CITY OF ALBUQUERQUE

February 02, 2012

**Re: Montessori Of The Rio Grande Charter School
Grading and Drainage Plan
Engineer's Stamp Date 1/09/2012 (H12/D008A)**

The proposed development will have a minor (<5%) impact on runoff which increases from 10.5 to 11.0 cfs. Onsite storm water detention with the proposed 5,700-gallon cistern and surface storage will mitigate this increase and minimize any impact on downstream drainage facilities.

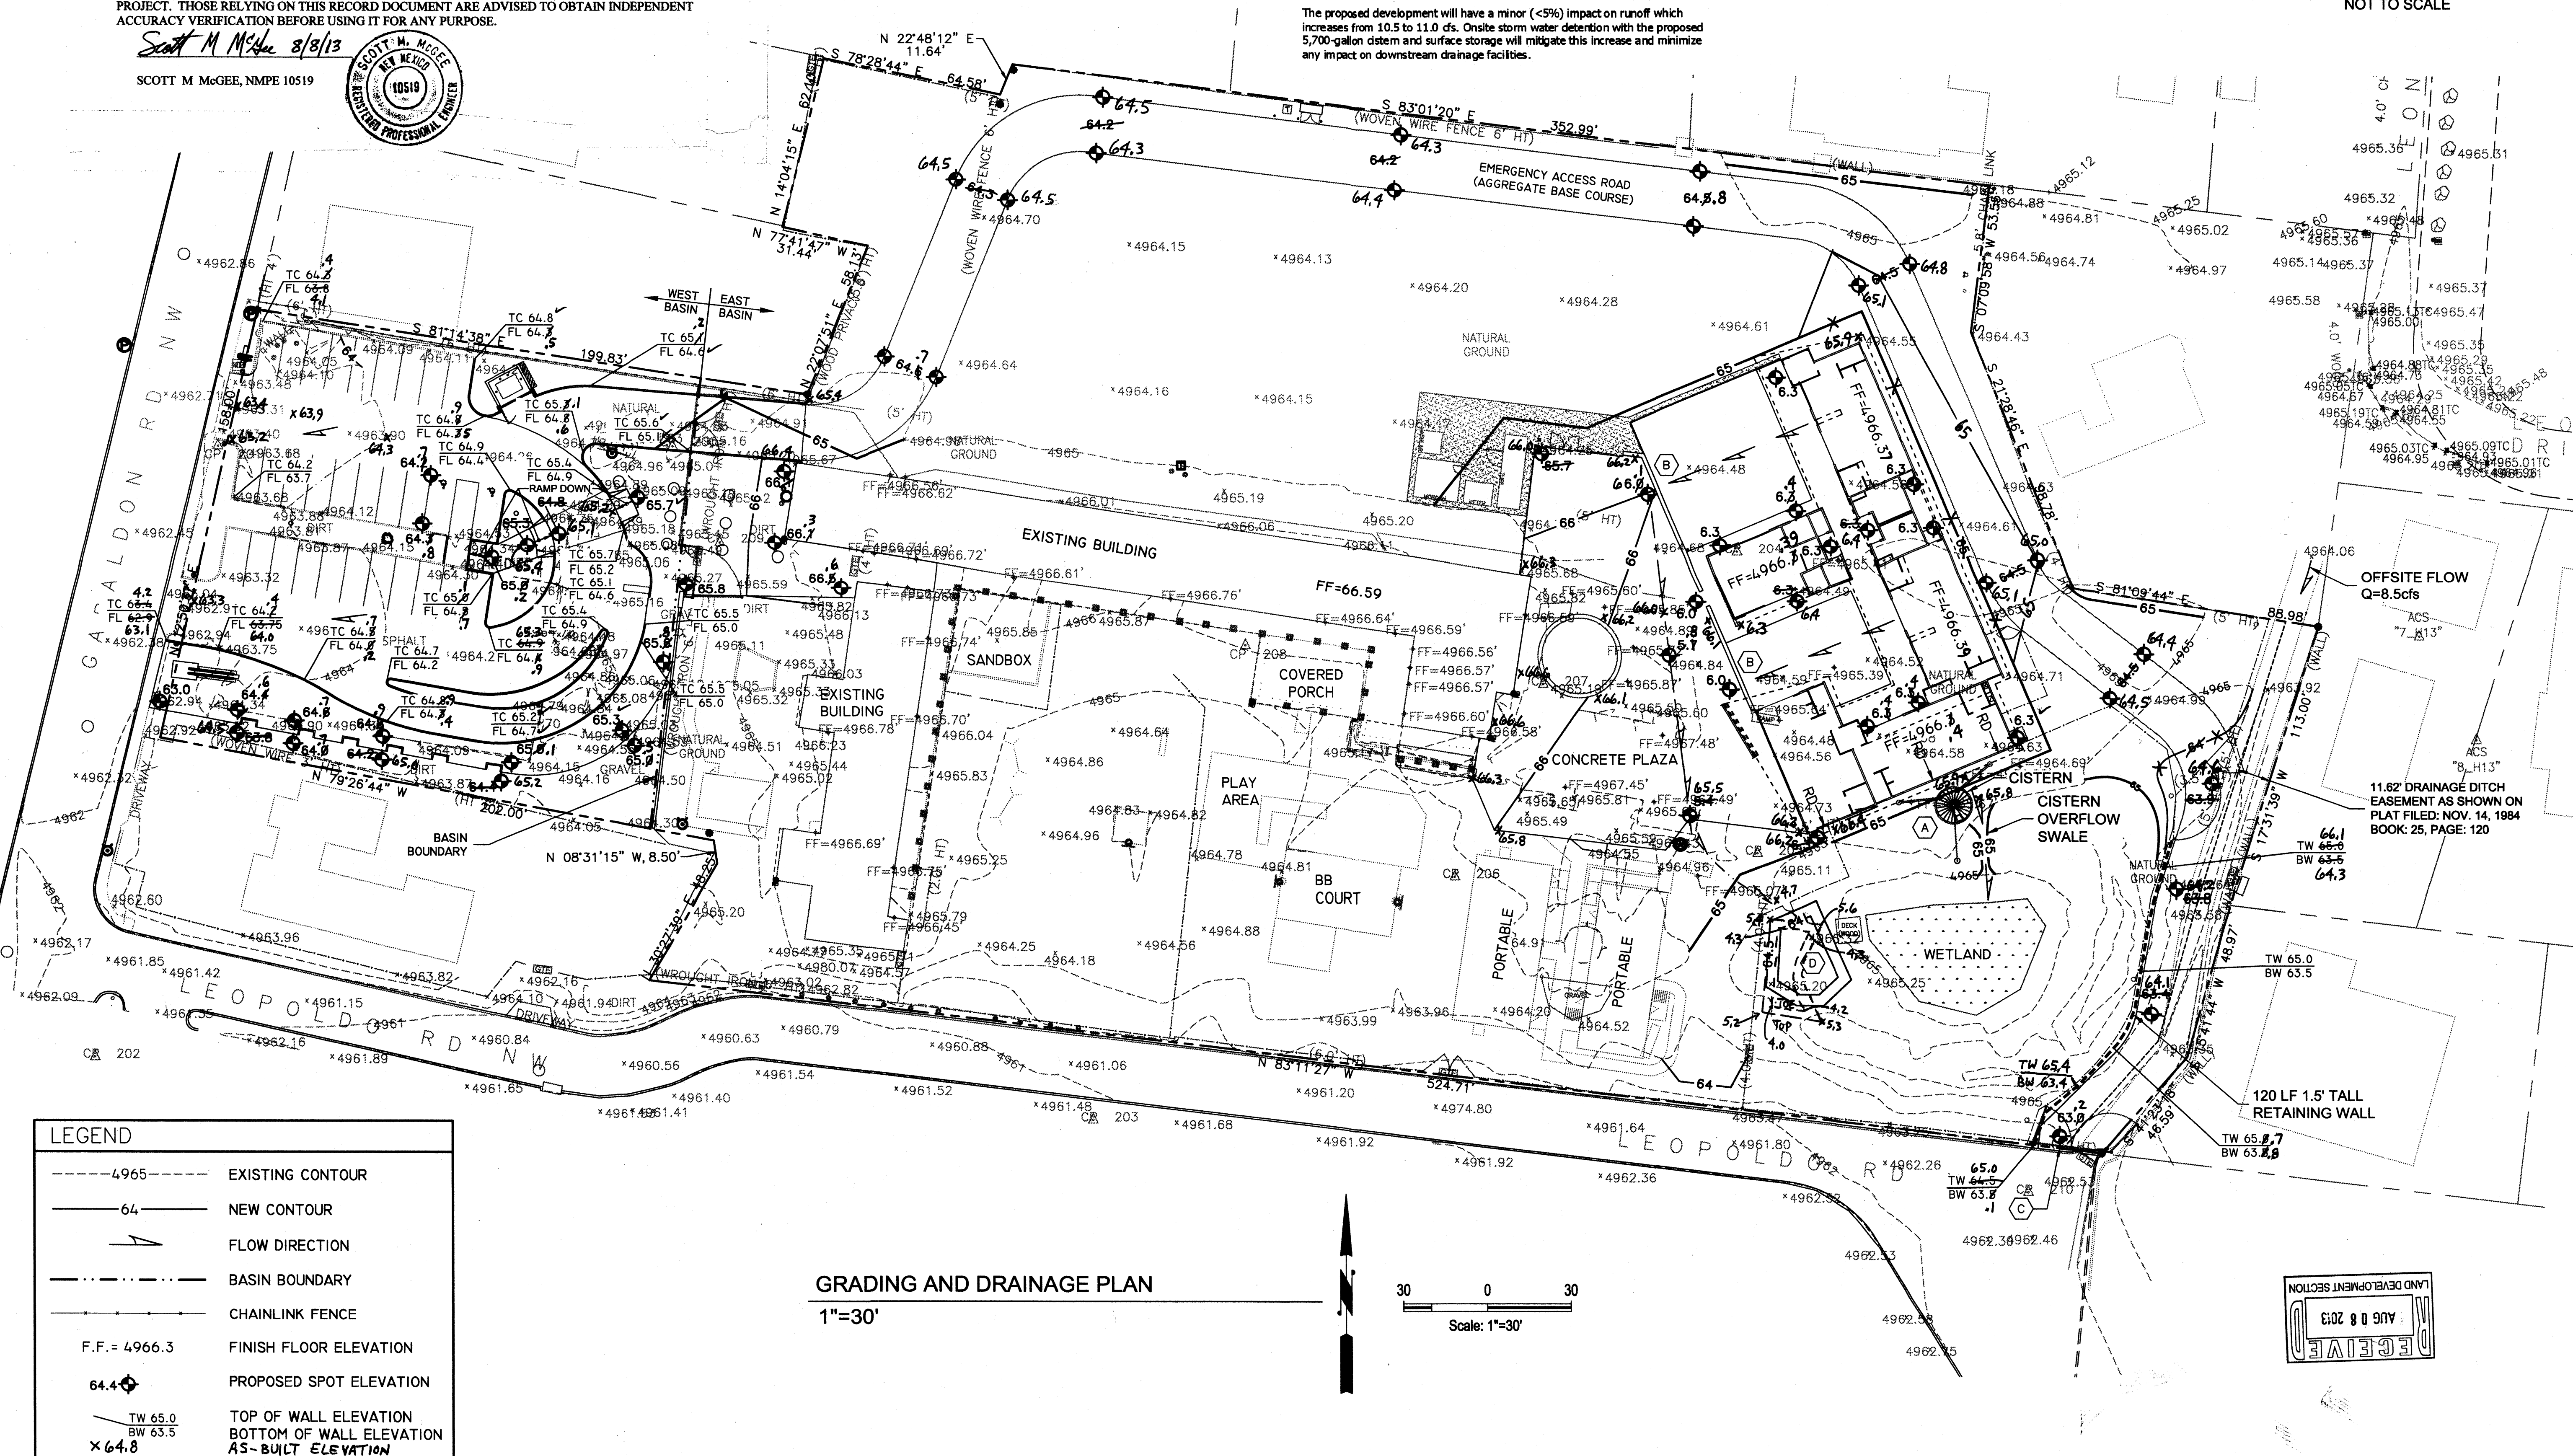
- Limits of the project are not fully reflected on the Vicinity Map.
- Lots B and C are zoned RA-1 and Lot A is zoned SU-1. Is the site being re-platted and rezoned? If so, please provide a copy of the preliminary plat.

- Provide more spot elevations along the boundary of Lots B and C. Increase the text size.
- How is the emergency access road being graded? Will it be super elevated? Provide spot elevations for this road.

- Clearly show the limits of the irrigation ditch on the plans. MRGCD approval will be required for any changes to the existing irrigation ditch.
- Are there any offsite runoff entering this site?

- It is mentioned on the plan that the changes to the parking lot are minor. Losing +/- 18 parking spaces does not appear to be minor changes.
- West basin runoff was increased slightly. Please depress the landscaping areas to retain portion of the runoff to match the exiting runoff.

- The area just south of the entrance appears to drain over the sidewalk. Please depress the landscaping to retain portion of the runoff. Please make sure that runoff does not drain to the property located south of the driveway.

- There are two spot elevations that are at 65.00 on the south side of the driveway. Please correct the elevations.
- Show the basin layout on the plan.

- Provide pond calculations for the existing pond and proposed ponds.
